KITITITAS COUNTY COMMUNITY DEVELOPMENT SERVICES

FORGEY SHORT PLAT
PART OF SECTION 23, T. 17 N., R. 19 E., W.M.
KITTITAS COUNTY, WASHINGTON

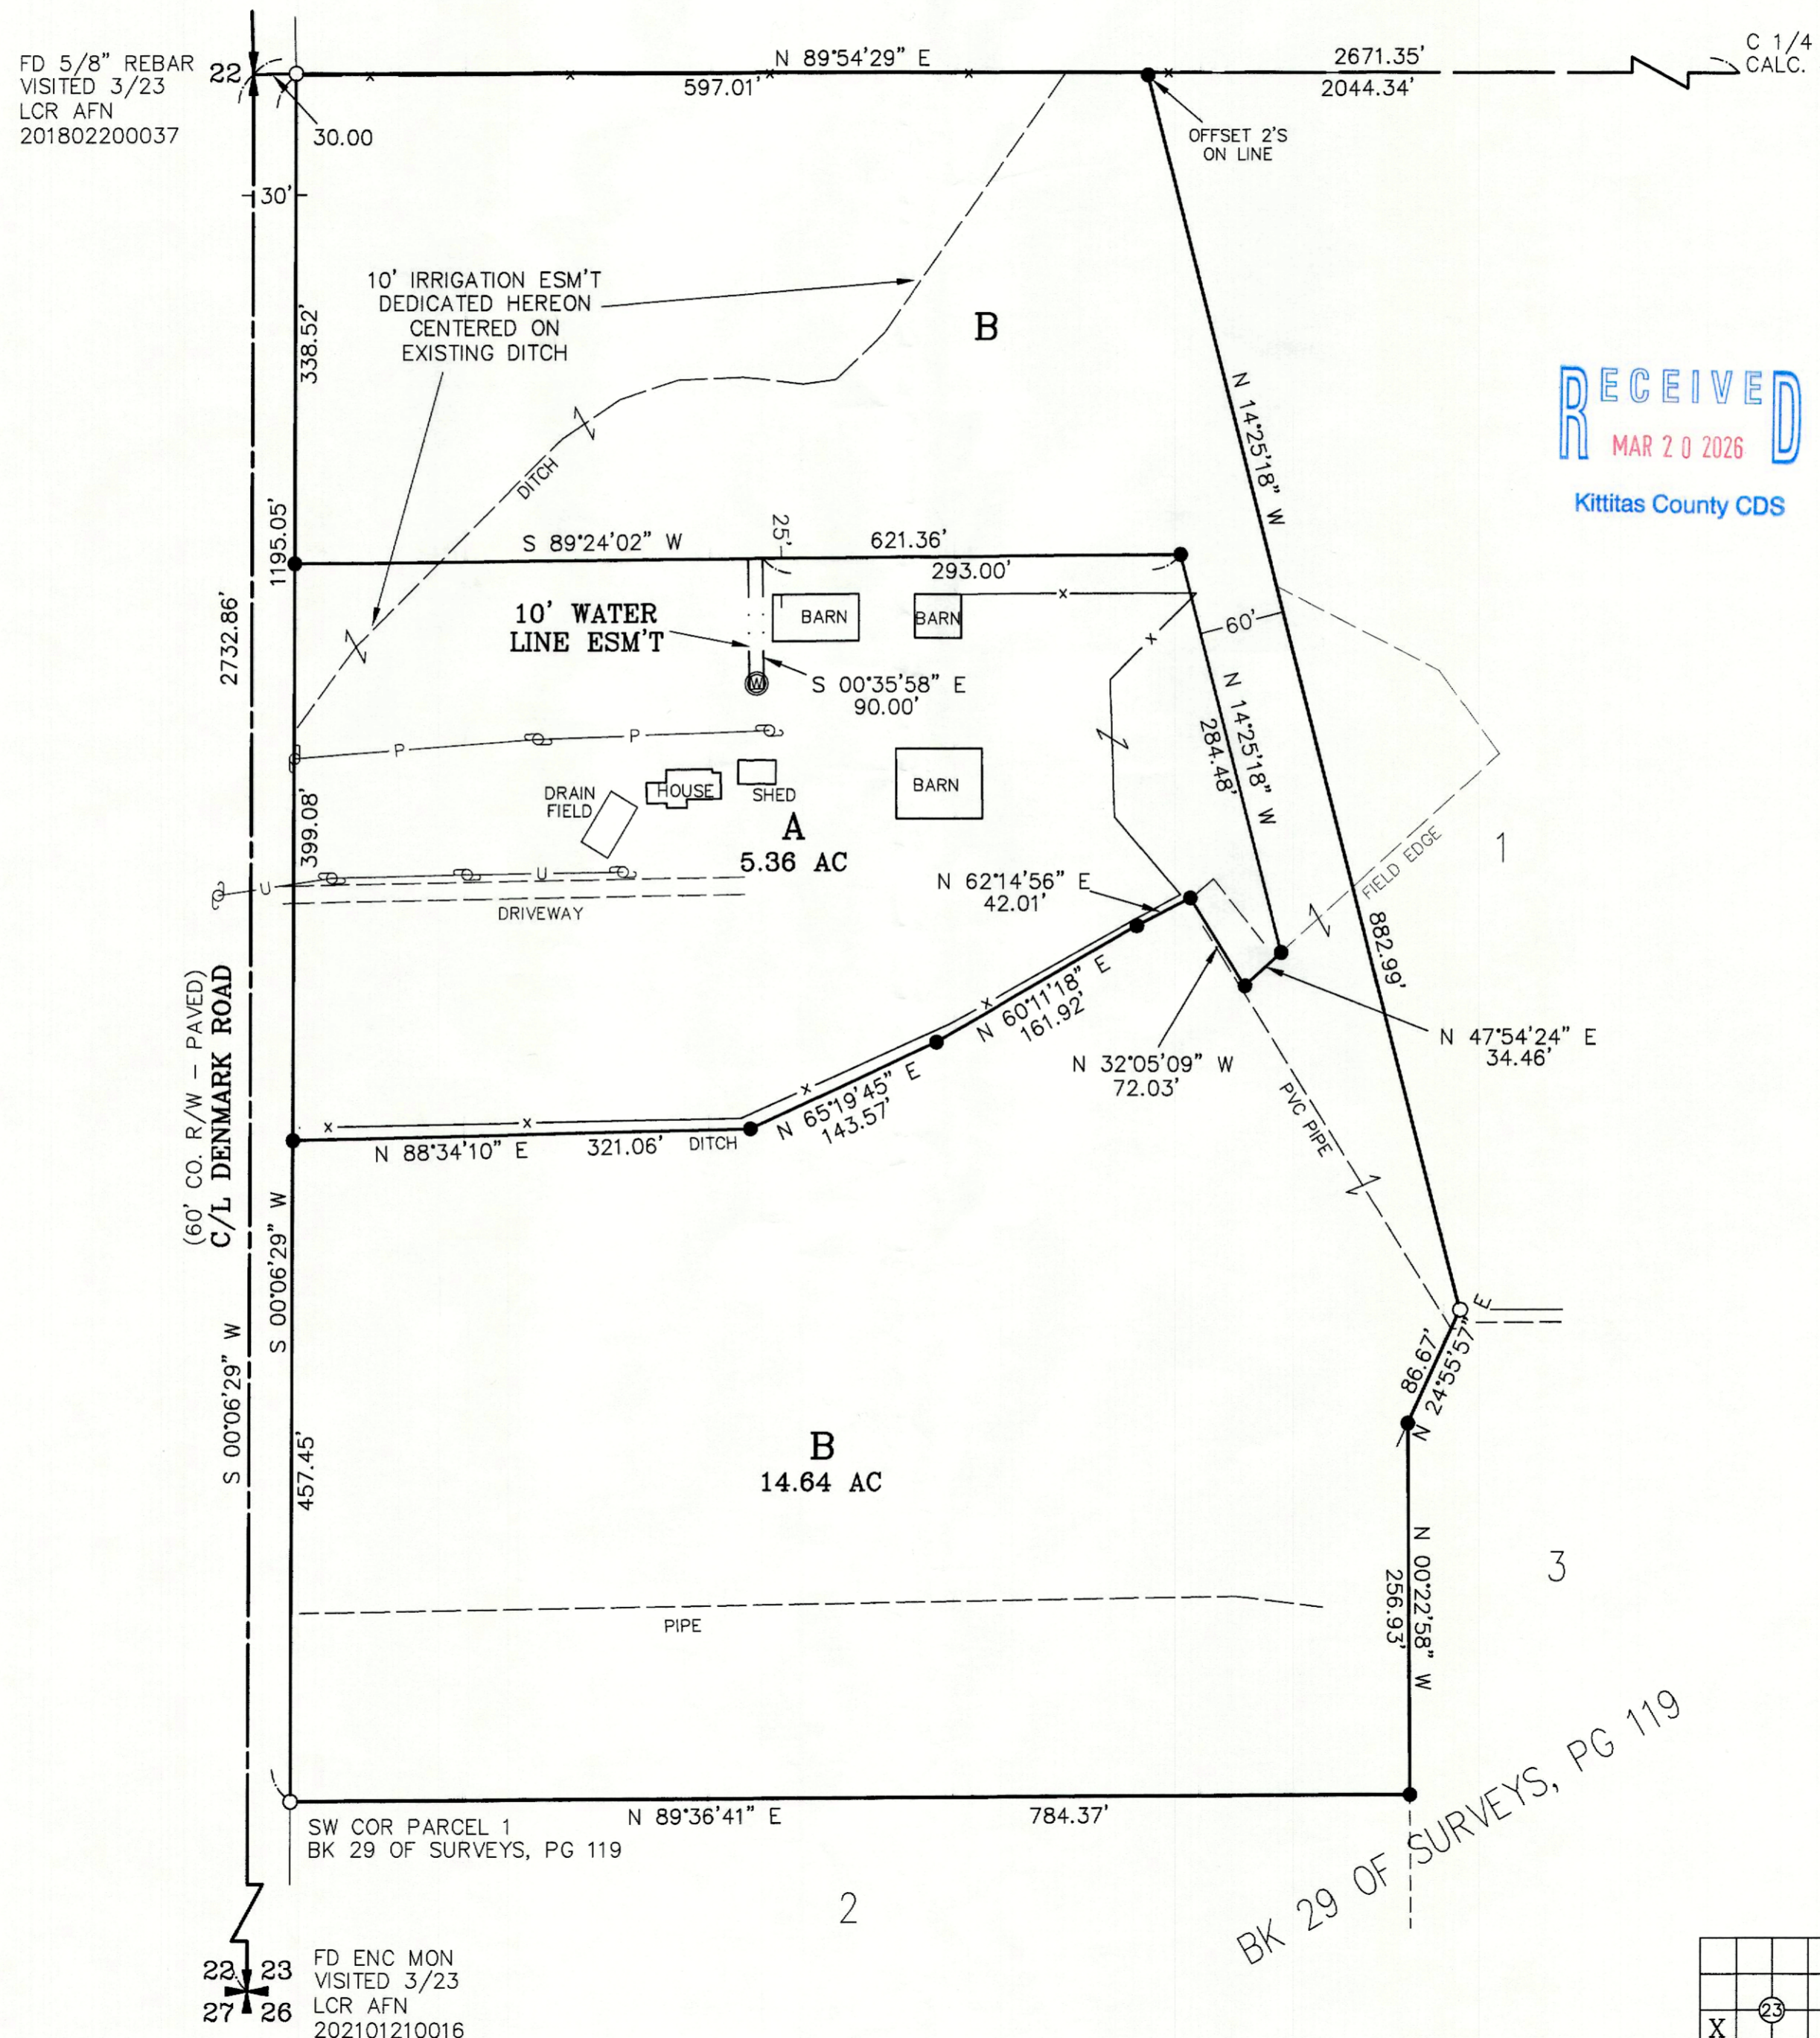
- G. Survey:
 - i. Prior to final approval, property corners will need to be shown on the new division line.
 - ii. Lot closure sheet is required prior to final approval (KCC 16.32.010(1))

- iii. Roads should identify ownership, surface type, width of R/W
 - iv. On the 2nd page is a typo at the top identifying the section number "29". It should be "23".

Noted
